## DEPARTMENT OF PUBLIC WORKS

### MEMORANDUM

TO: Jeff Watson, CDS  
FROM: Christina Wollman, Planner III *CW*  
DATE: June 8, 2015  
SUBJECT: McIntosh CU-14-00004

### **DETERMINATION OF CONCURRENCY FINDING**

EXISTING
OUTDOOR ARENA

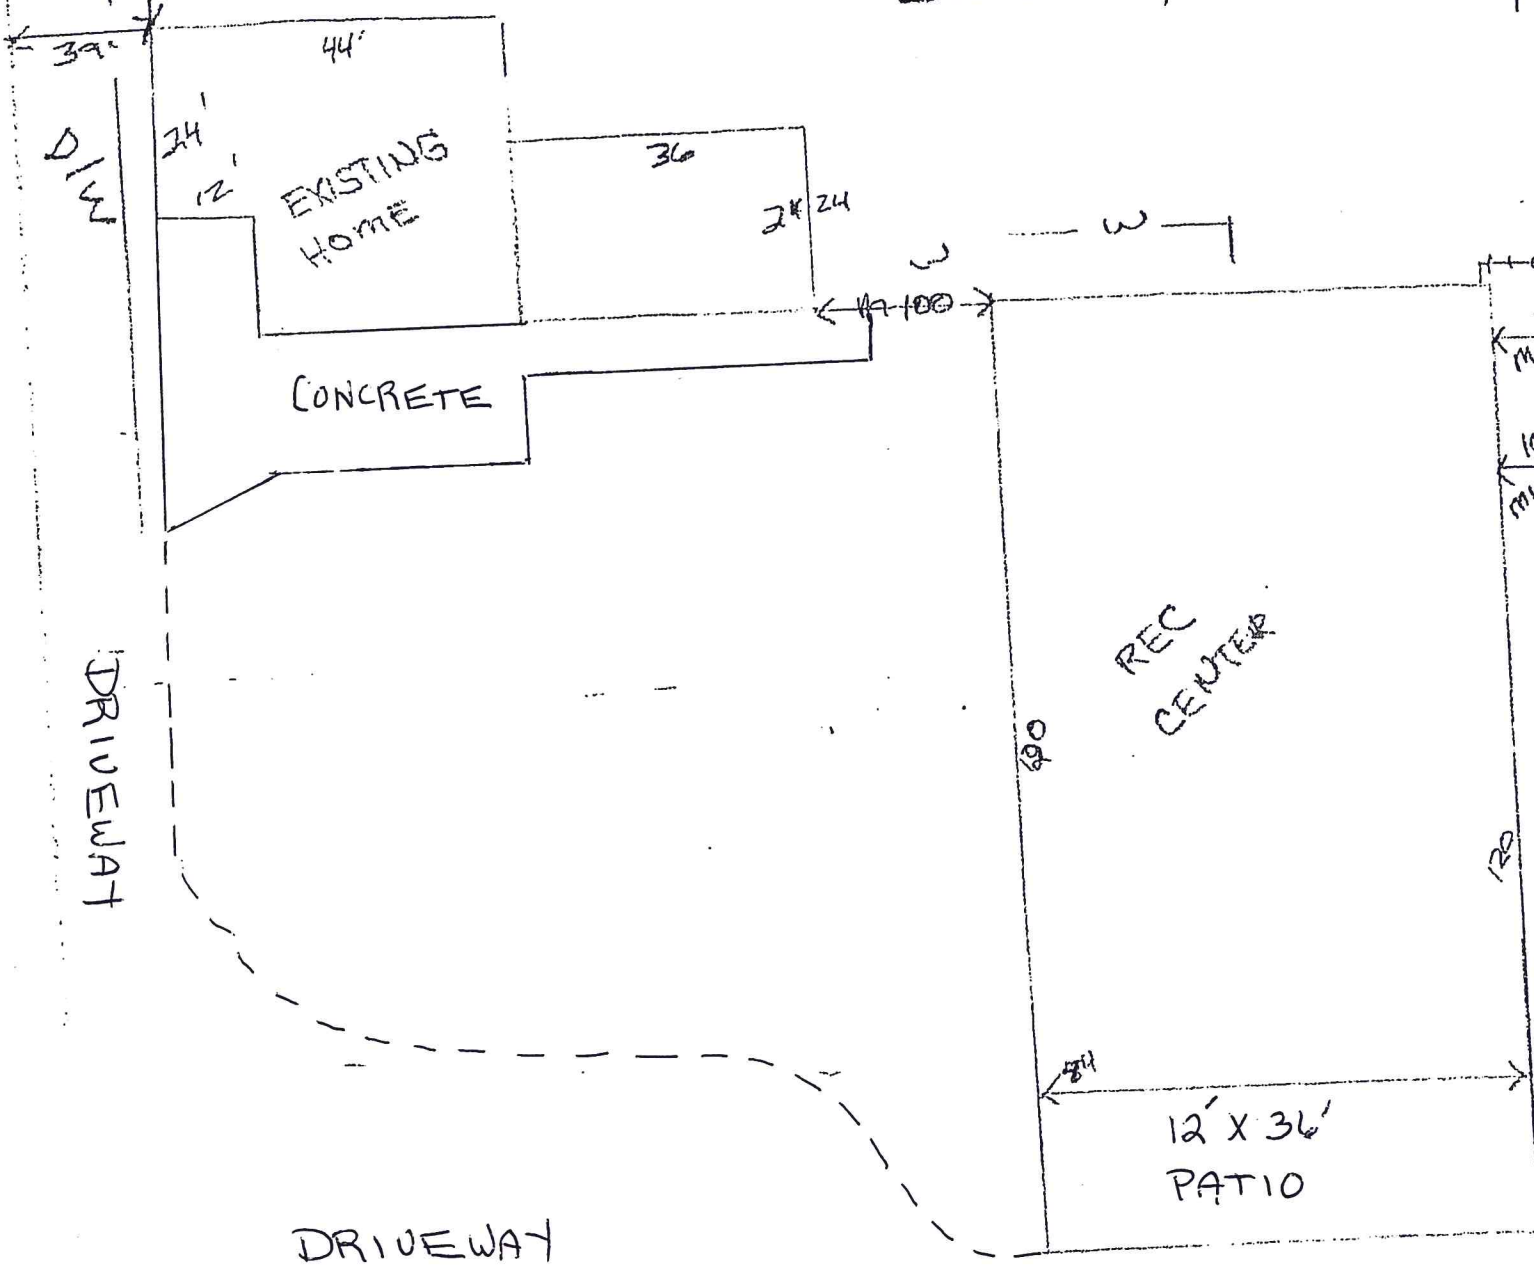
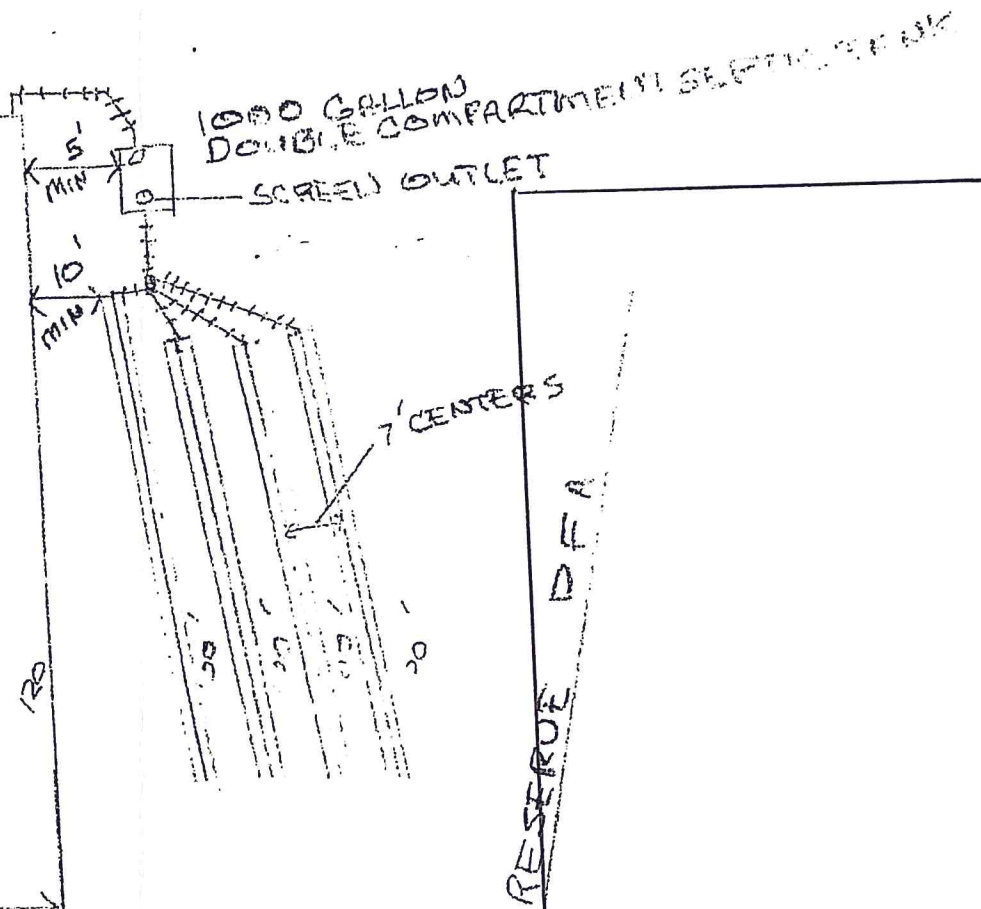
- A. Transportation Concurrency: A Determination of Concurrency Finding has been issued for this project under number TC-15-00002, through joint review by Kittitas County and WSDOT. Conditions have been required in order to avoid the need to mitigate. If the conditions are not sufficient to avoid back-ups onto the highway or the conditions are not complied with, WSDOT may require mitigation in the future.
- B. Site Access: The site accesses from US 97 and has an approved WSDOT access permit allowing up to 100 daily trips.

1. The proponent must widen the entrance to permit two-way traffic without slowing the movements of motorists entering the site. The widened entrance must be maintained.
2. A parking facilitator must be on site to direct traffic to prevent slowing the movements of motorists entering the site.
3. If backups onto US 97 occur, the proponent will be required to widen the highway and construct a right turn lane as required by WSDOT.

As such, the design vehicle is a passenger car and the current commercial Access connection permit with the proponent is valid. And authorizes 100 daily trips. No further improvements are necessary within WSDOT jurisdiction, provided the County requires the proponent to “open up” the approach at the property boundary. Eg-brush and tree limb removal to permit two way traffic that doesn’t slow the movements of the ingressing motorists. A parking facilitator during events, would be beneficial to keep the ingressing traffic moving. If this mitigation is required by the County, there shouldn’t be a problem affecting the approach from the highway.
